Submission for Job: #6011 SSD 6011 - Mixed use residential development within the South West Plot

Site: #2825 SICEEP Site, The Haymarket; Darling Drive, Sydney

SSD 6011 - Mixed use residential development within the South West Plot

## Winter Solstice (21<sup>st</sup> June)

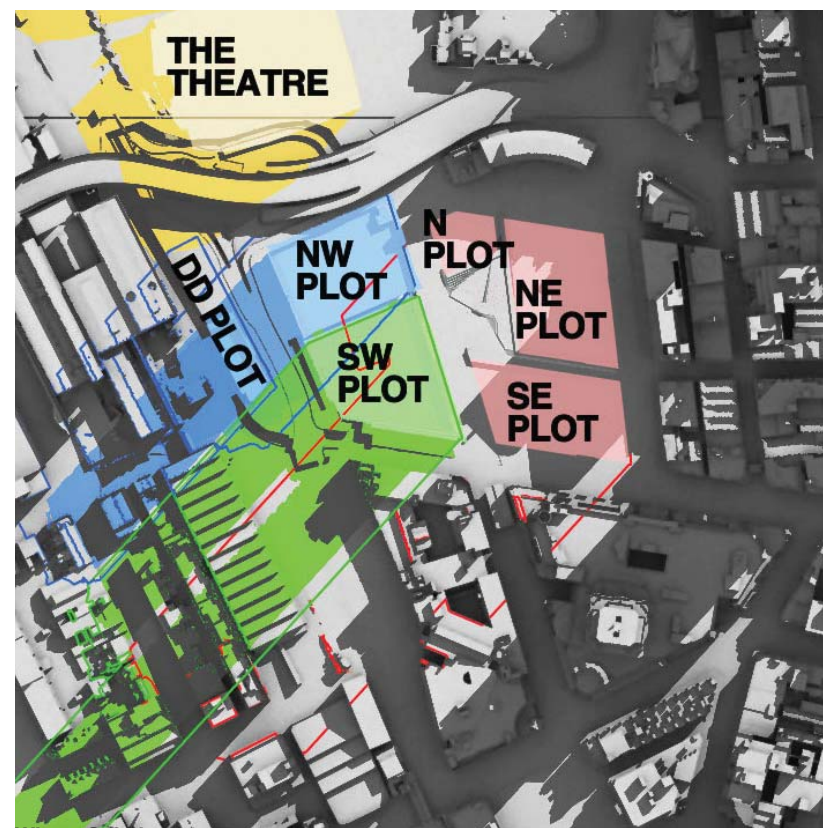
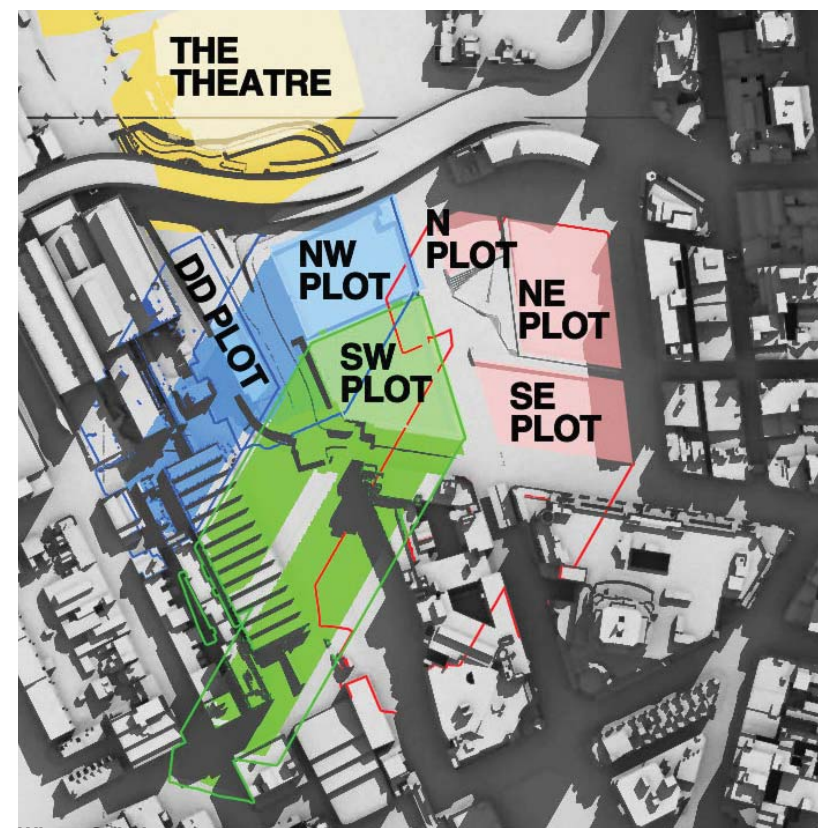
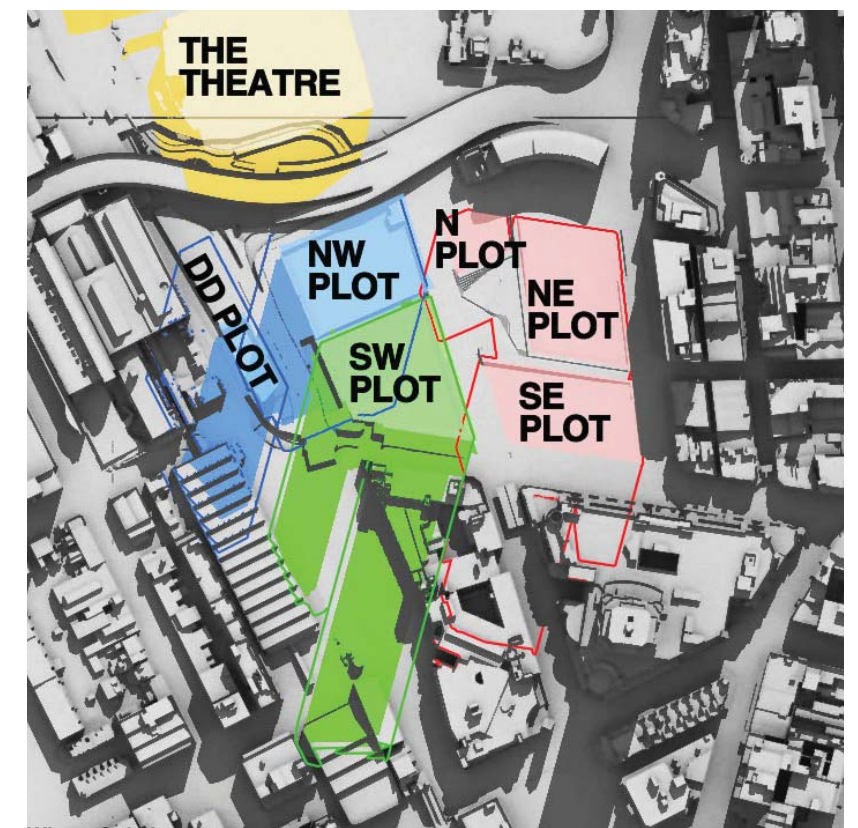
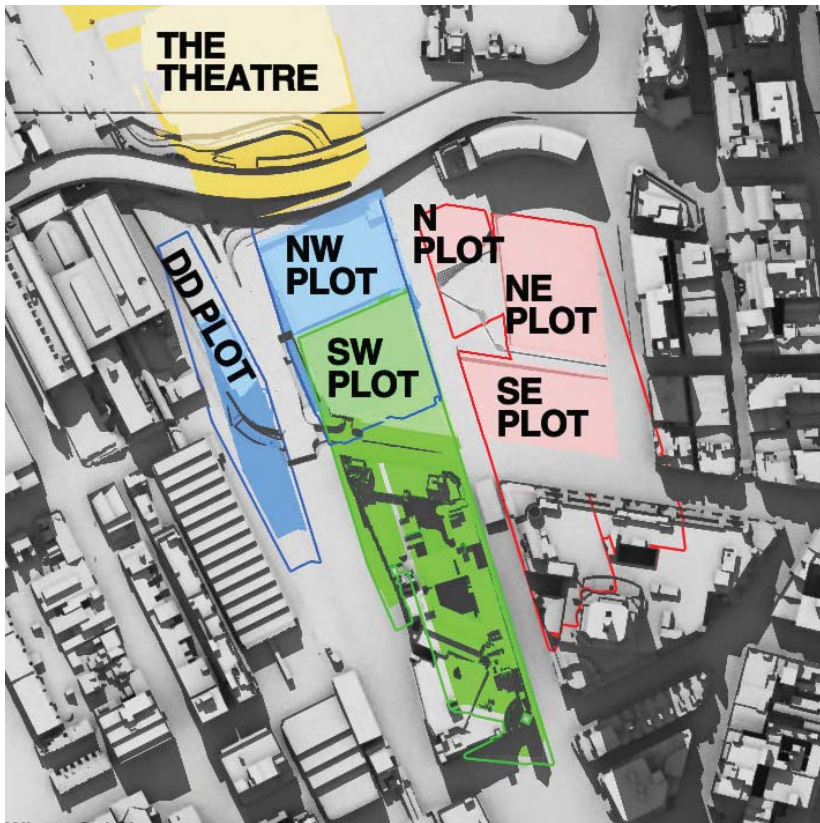
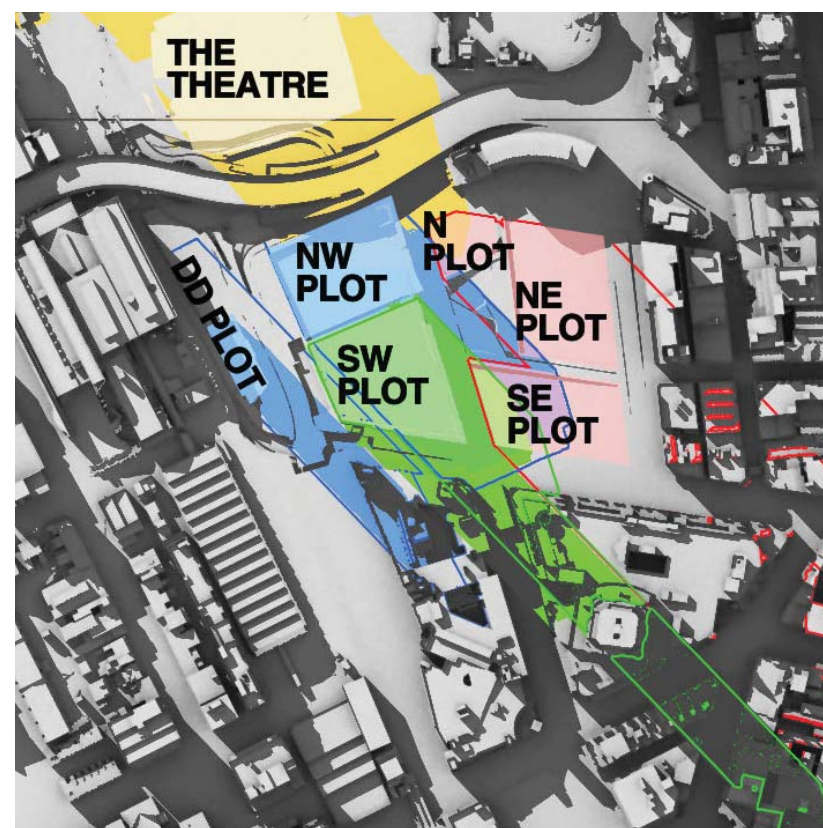
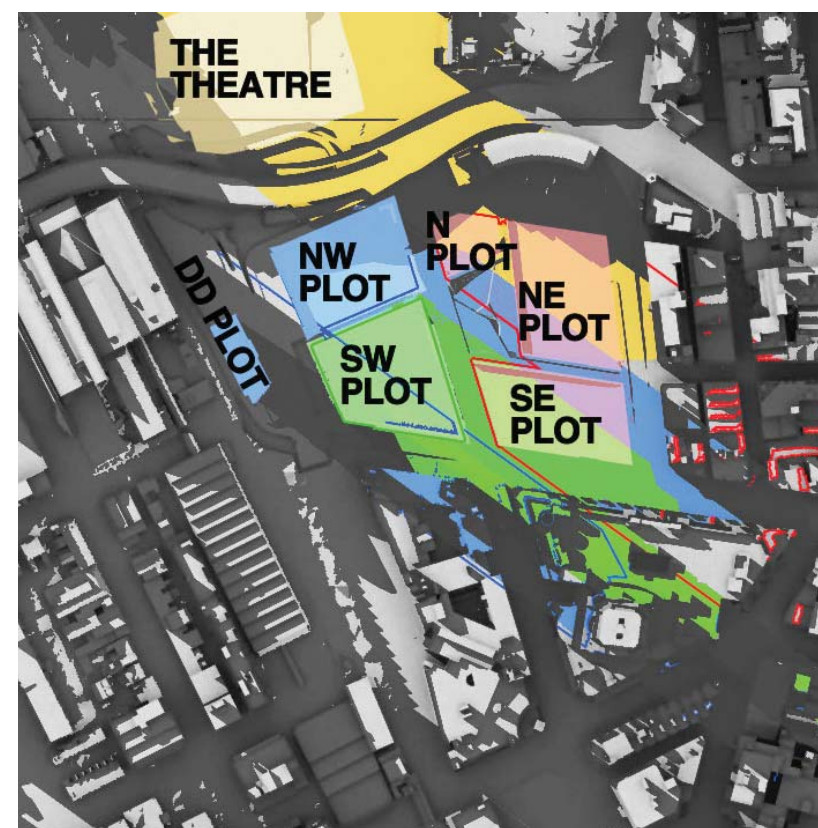
The proponent provides diagrams but fails to discuss the existing shadowing of the west façade of The Peak.

At 9am, 10am and 11am the west façade is totally in shadow due to other parts of The Peak building itself.

At 12pm there is still substantial existing shadowing on the west façade caused by the irregular shape of the west facade.

At 1pm the existing shadowing has been substantially removed, but not totally removed.

It can be concluded that some single aspect apartments on the west façade and some south-west dual aspect corner apartments currently receive less than 2 hours direct sunlight to habitable rooms and 50% of the private open space between 9am and 3pm on 21 June.

By 2pm the existing shadowing has been totally removed, but that is too late to achieve two hours of direct sunlight before 3pm.

At 9am, 10am and 11am the west façade is totally in shadow due to other parts of The Peak building itself.

At 12pm there is still substantial existing shadowing on the west façade caused by the irregular shape of the west facade.

At 1pm the existing shadowing has been substantially, although not entirely, removed. However, overshadowing of lower levels of the west façade by the concept proposal parameter plan shadows for the N,NE and SE plots has already started.

By 2pm the existing shadowing has been totally removed. However, overshadowing of the west façade by the SSDA4 and SSDA5 buildings has appeared and risen further up the west façade than the concept proposal parameter plan shadows for the N,NE and SE plots, which is still present.

At 3pm, the proponent states correctly that 45-45% of the western façade is overshadowed by the SSDA4 and SSDA5 buildings.

It can be concluded that, as a result of combination of the proposed development with existing shadowing of the west façade, some single aspect apartments on the west façade and the south-west dual aspect corner apartments which currently receive less than 2 hours direct sunlight to habitable rooms and 50% of the private open space between 9am and 3pm on 21 June will suffer additional overshadowing. It is beyond our skills to count the number of such apartments. We note that the proponent has made no attempt to do so.

Rather than counting the number of units which will not meet the DCP guidelines, the proponent attempts to trade-off direct sunlight at 4pm for lack of direct sunlight during the period 9am to 3pm. There is no provision in the DCP guidelines for such a trade-off.
